ENG-CDR18006-CDs-V1-Redlines.pdf Markup Summary

006

**LORSON BOULEVARD
SIGNING/STRIPING PLAN**

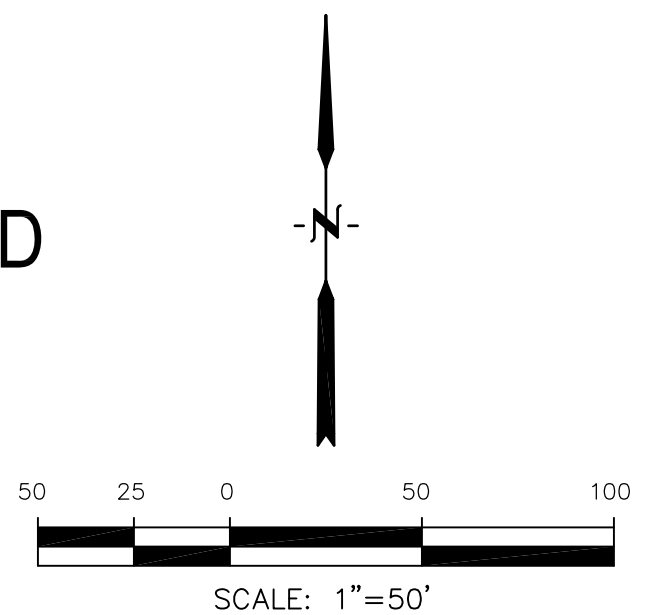
Add pedestrian signs each side.

double yellow?

4" double yellow

delete extra text?

STREET/STORM
LORSON BOULEVARD
STA 52+00 TO 60+00

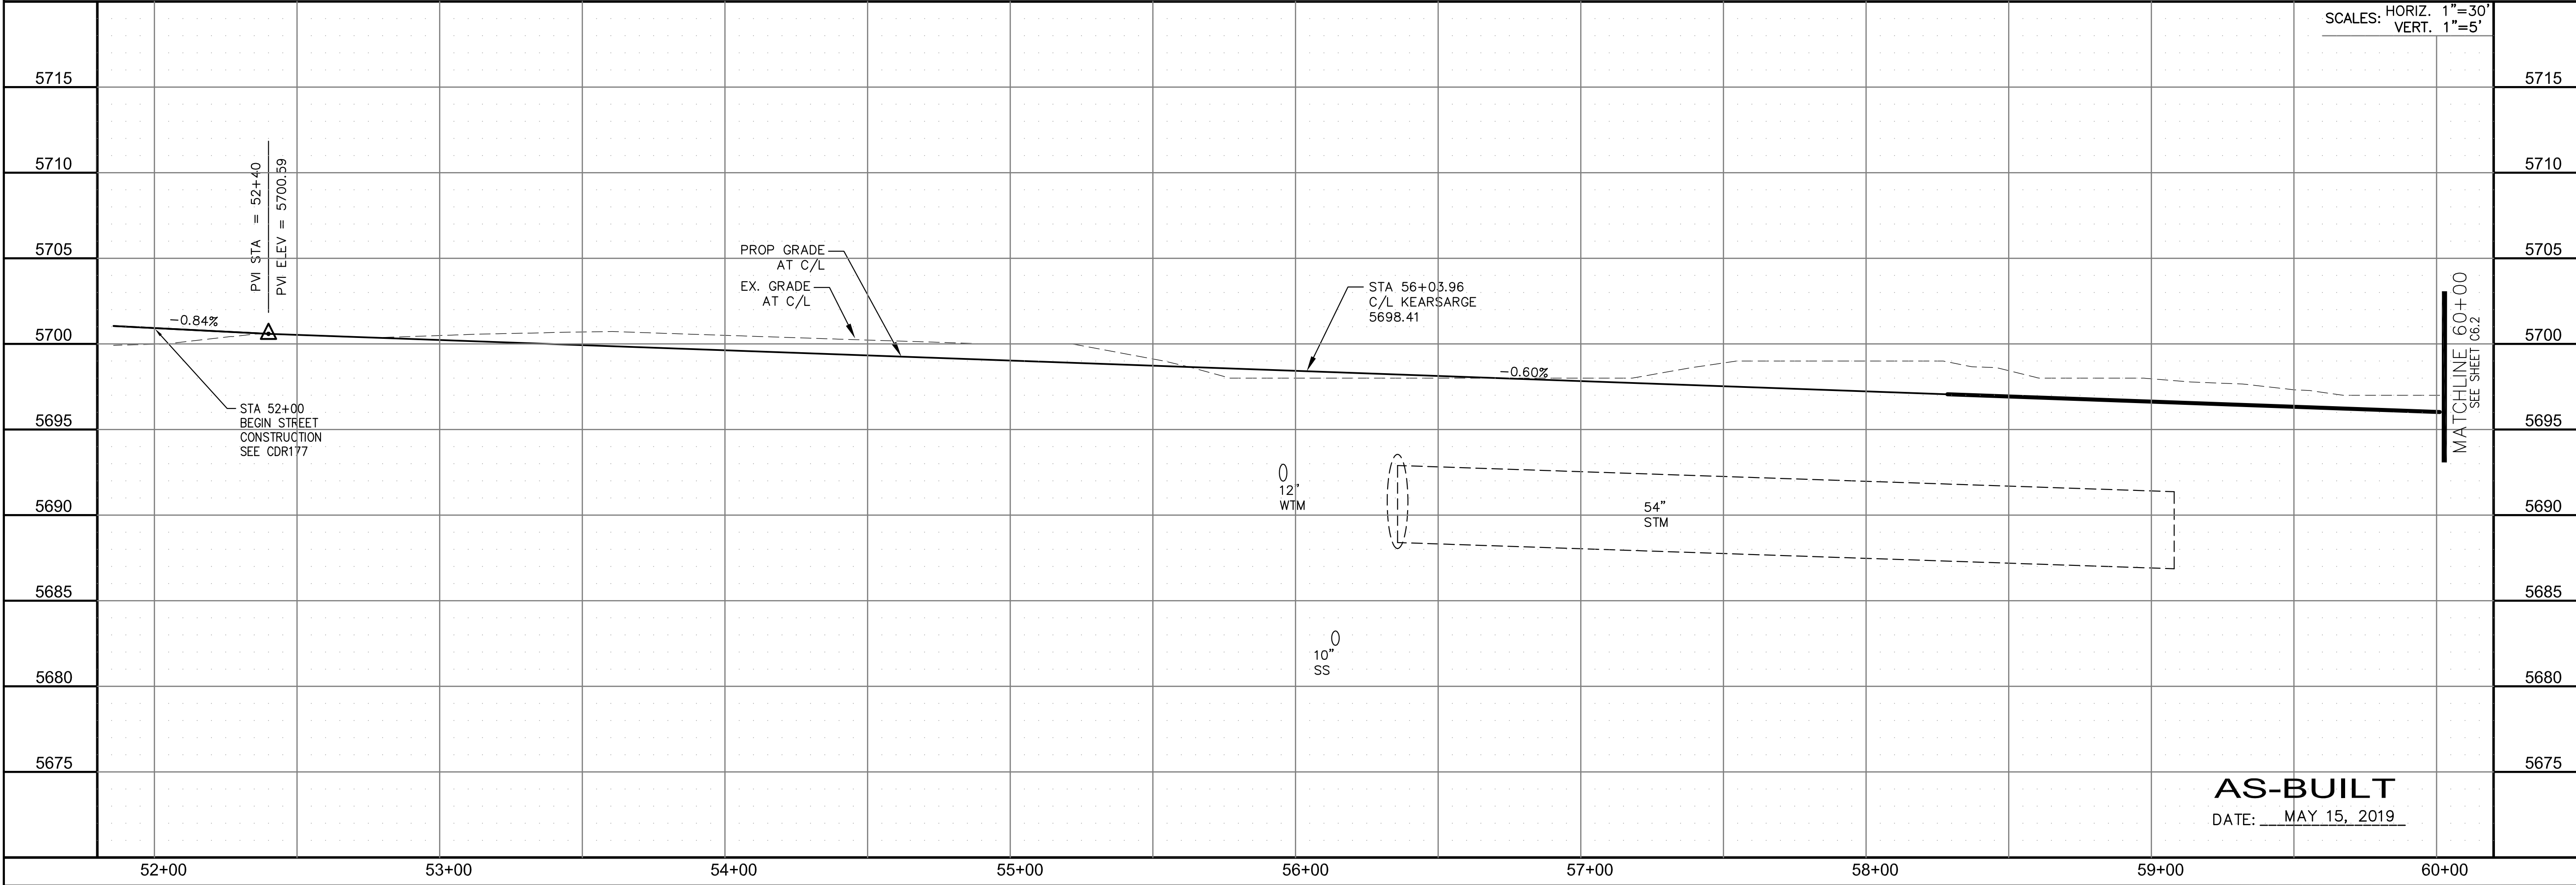
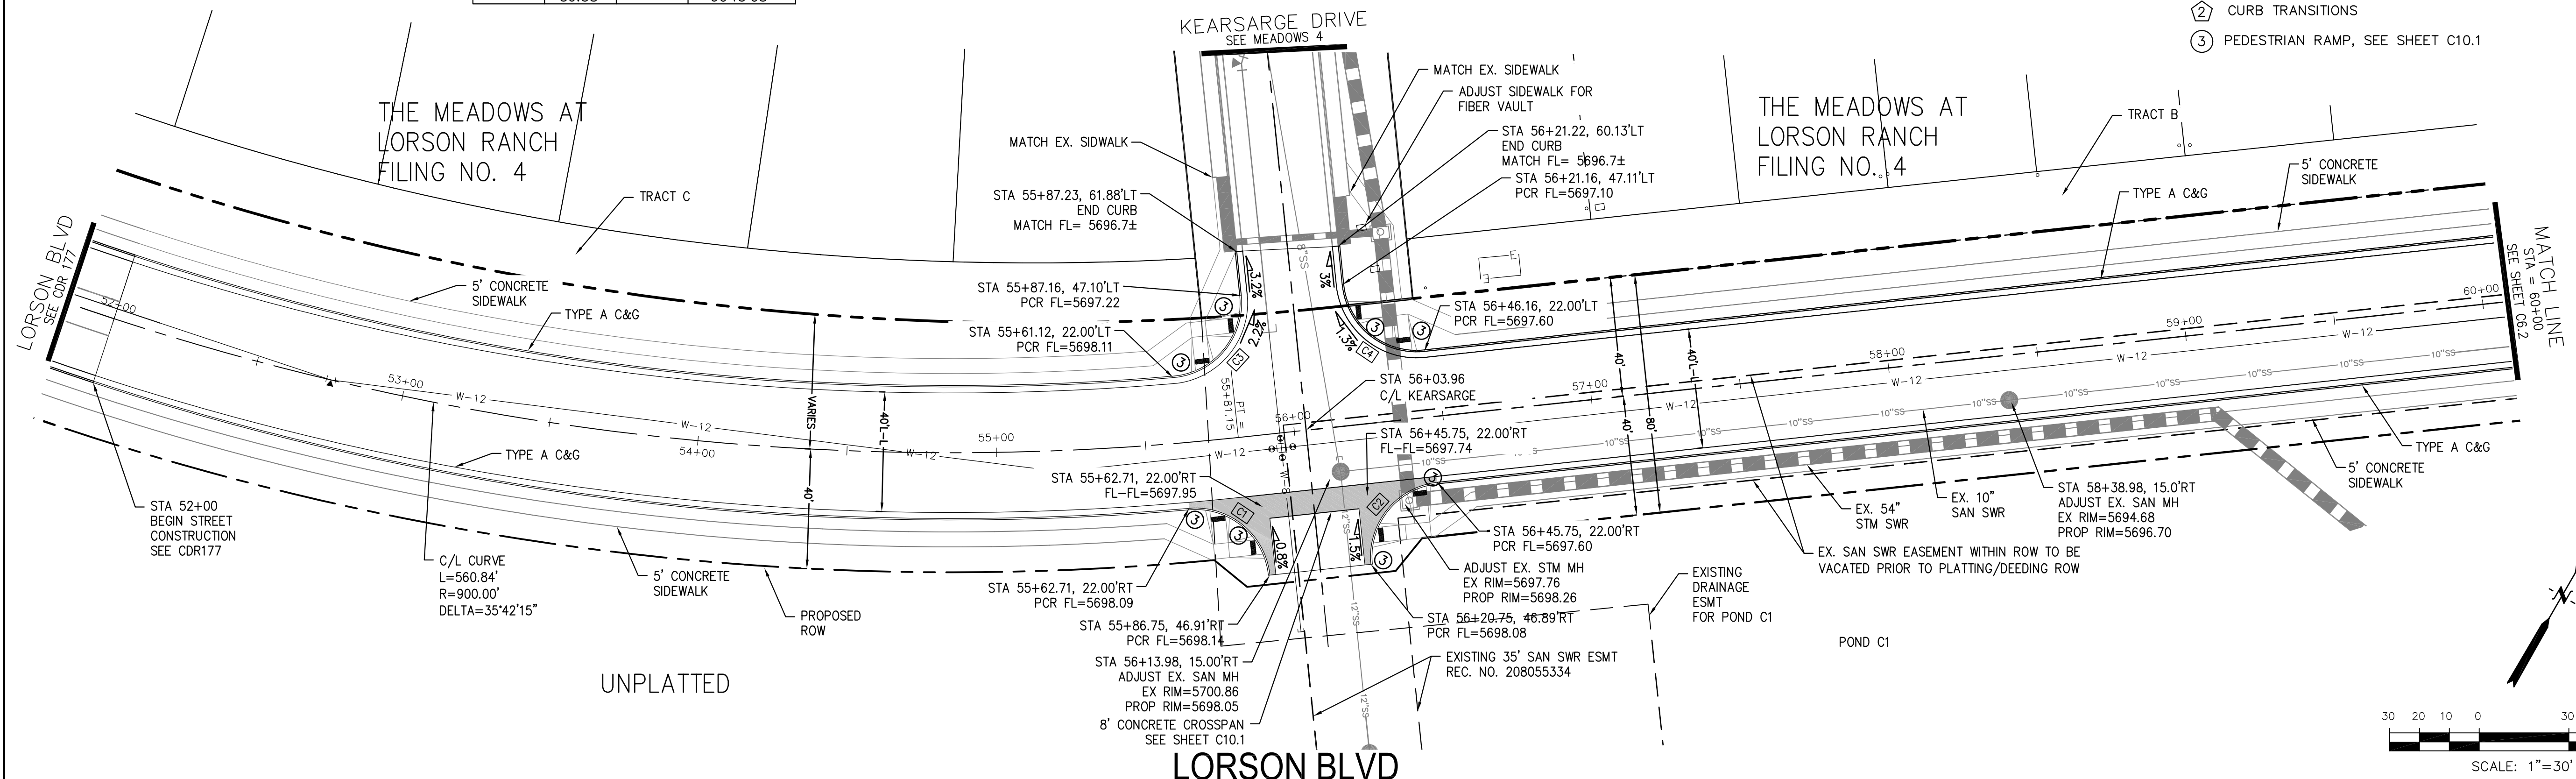
Is this in an existing easement? Label if so.

Label begin construction

Portions to be vacated prior to platting/deeding ROW.

STREET/STORM
LORSON BOULEVARD
STA 60+00 TO 67+50

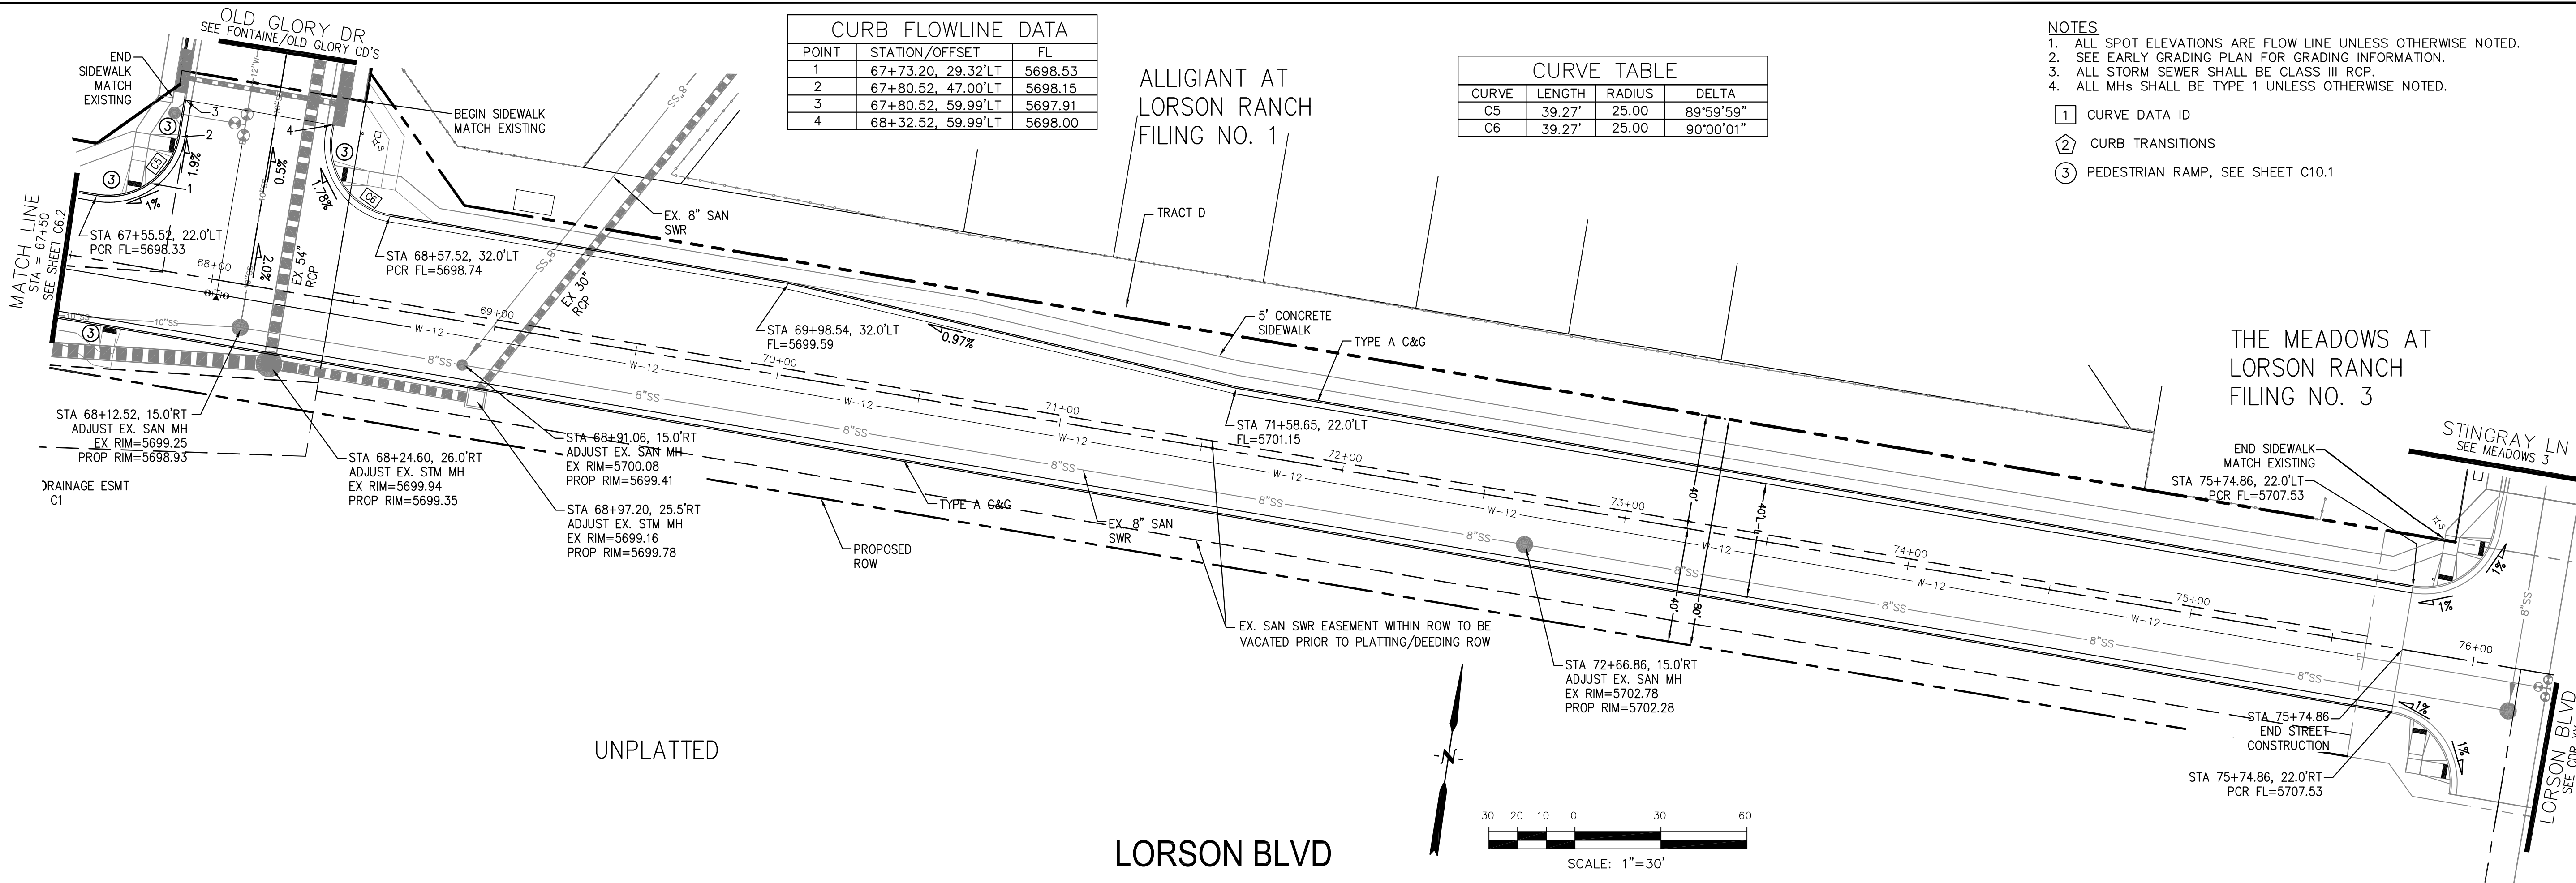
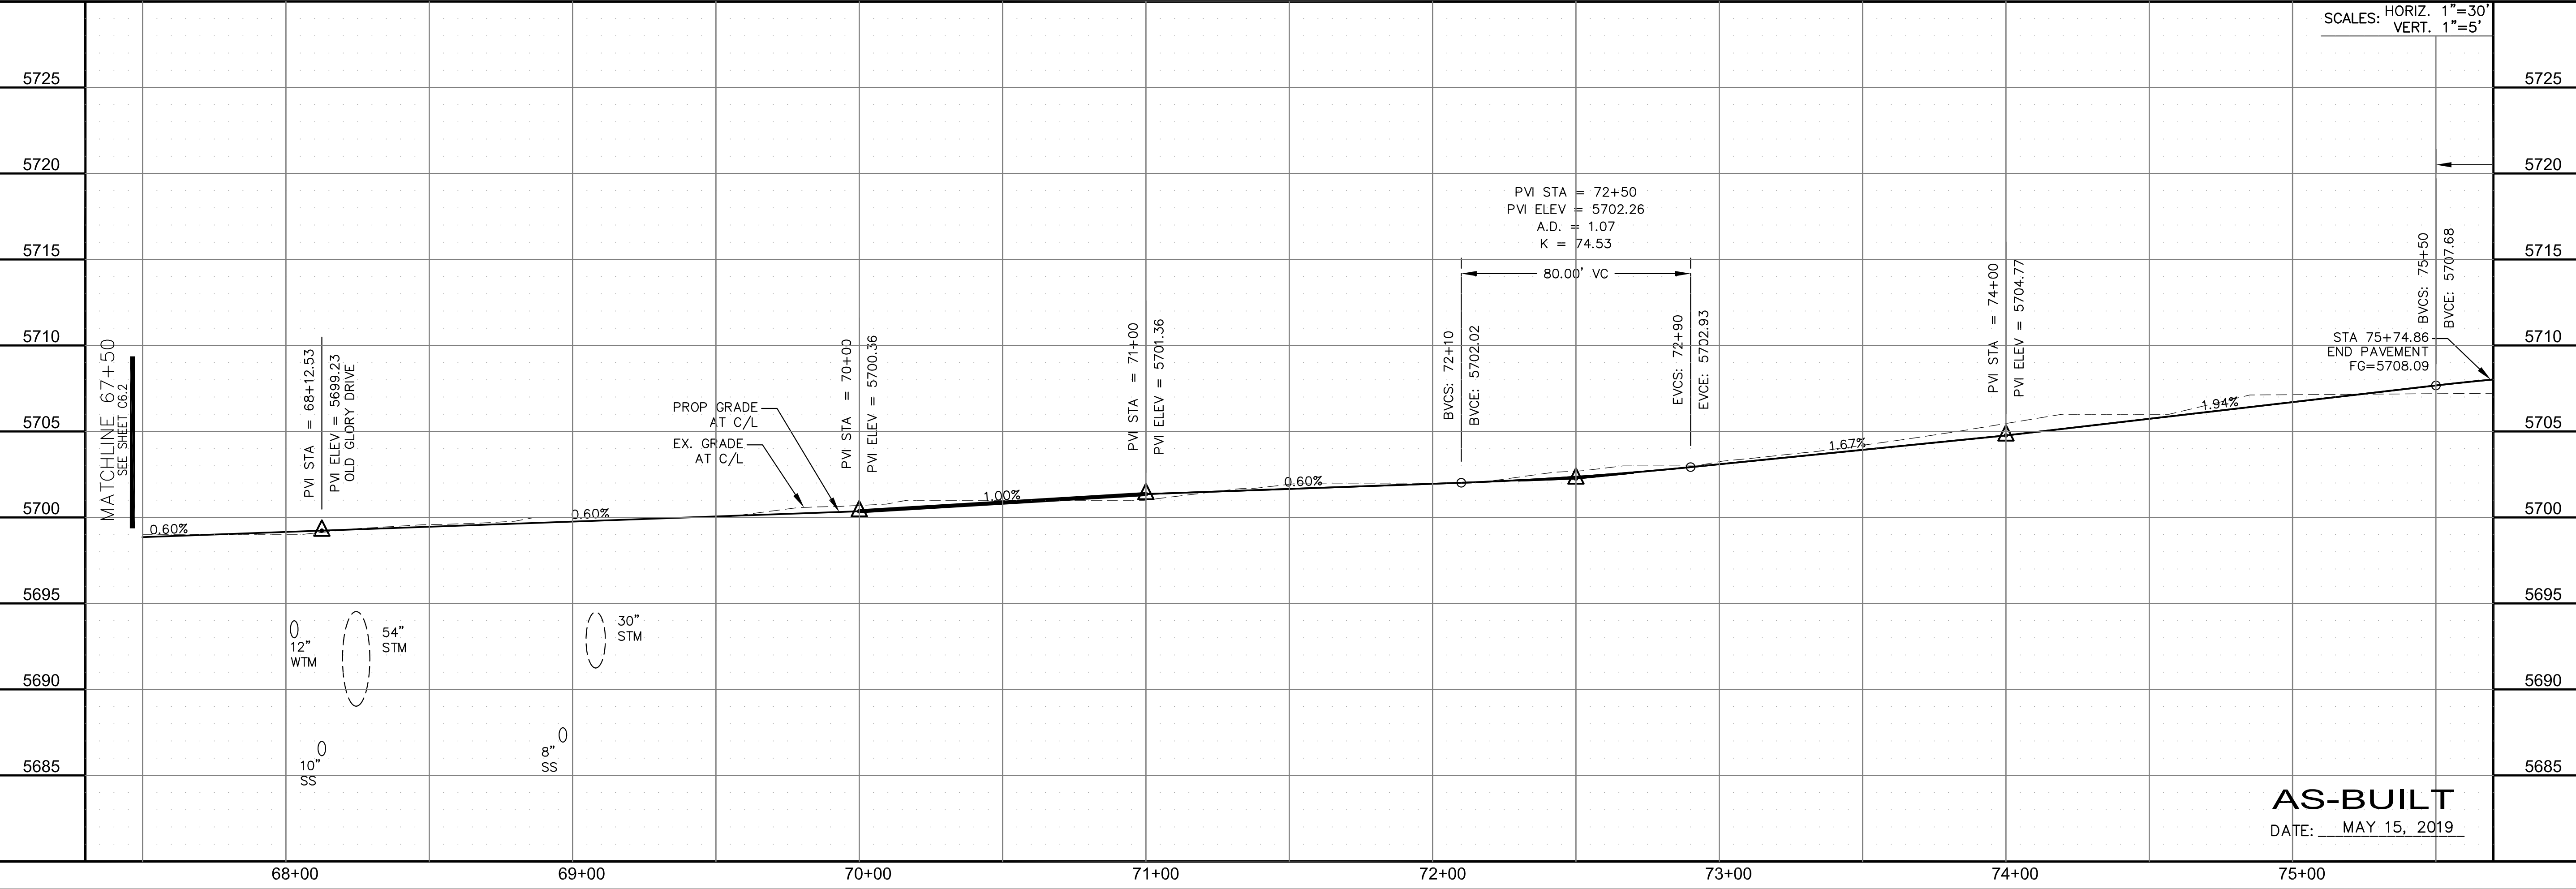
Is this in an existing easement? Label if so.

Label
